Application No: P/157/21/PL
Site Address: 31 Lagoon Road Pagham PO21 4TQ
Description of works: Demolition & erection of 1 No dwelling (resubmission following P/56/21/PL). This site is in CIL Zone 4 and is CIL Liable as new dwelling.

Thank you for your internet representation made on 17th January 2022 which has been recorded as an objection with the comments as follows:

DRAWING NUMBER: B_200

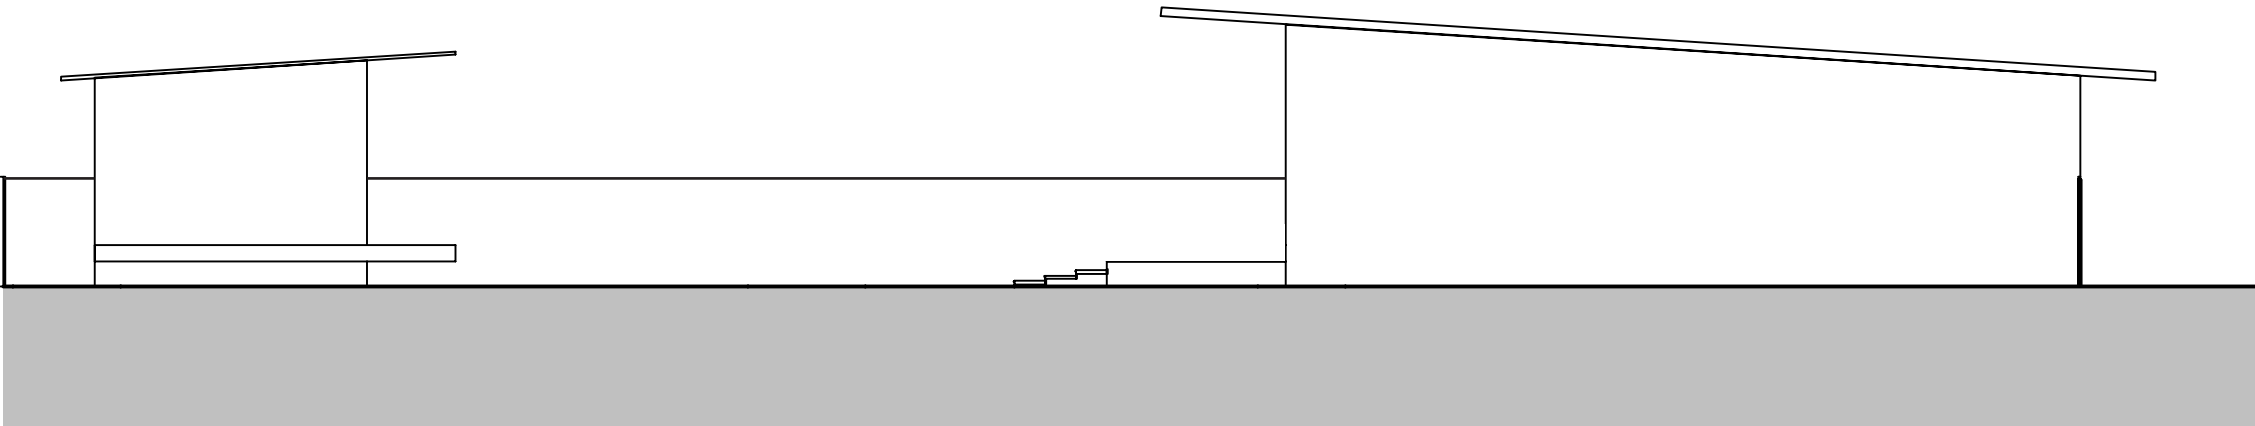
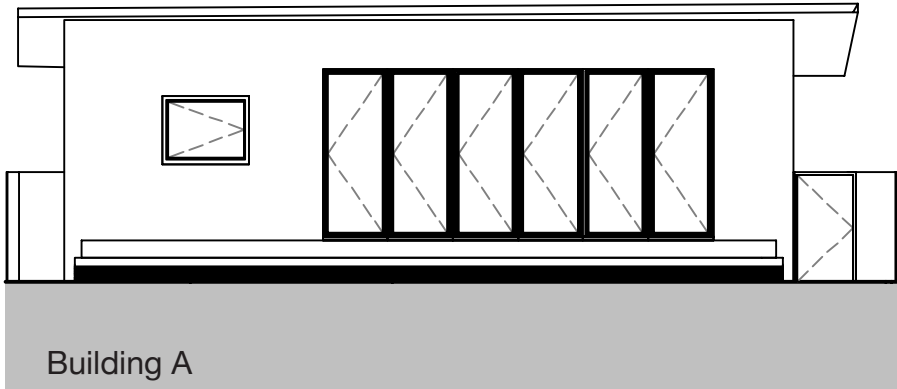
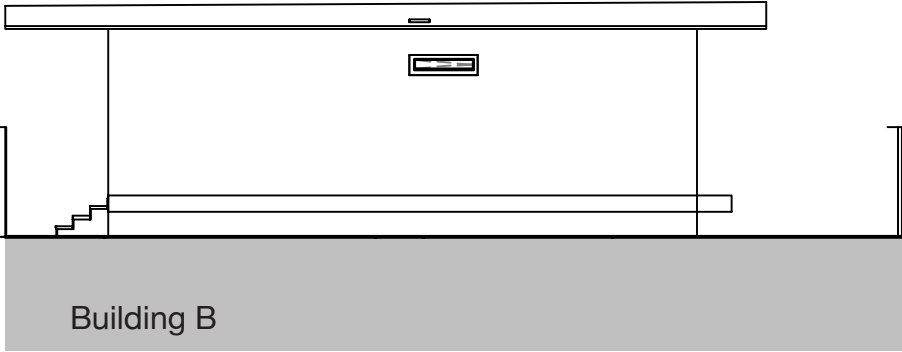
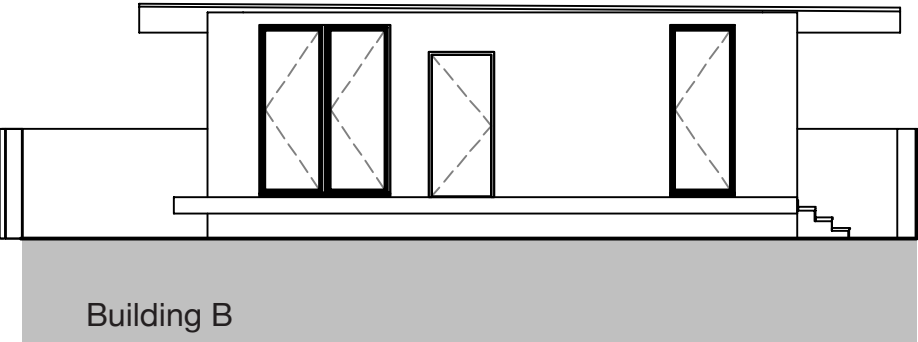
The objection hinges upon building B which will impact upon our outlook and provides for an opening window in the proposed bathroom which looks out over our property will result in the sounds attendant on the use of such facilities being audible in our garden
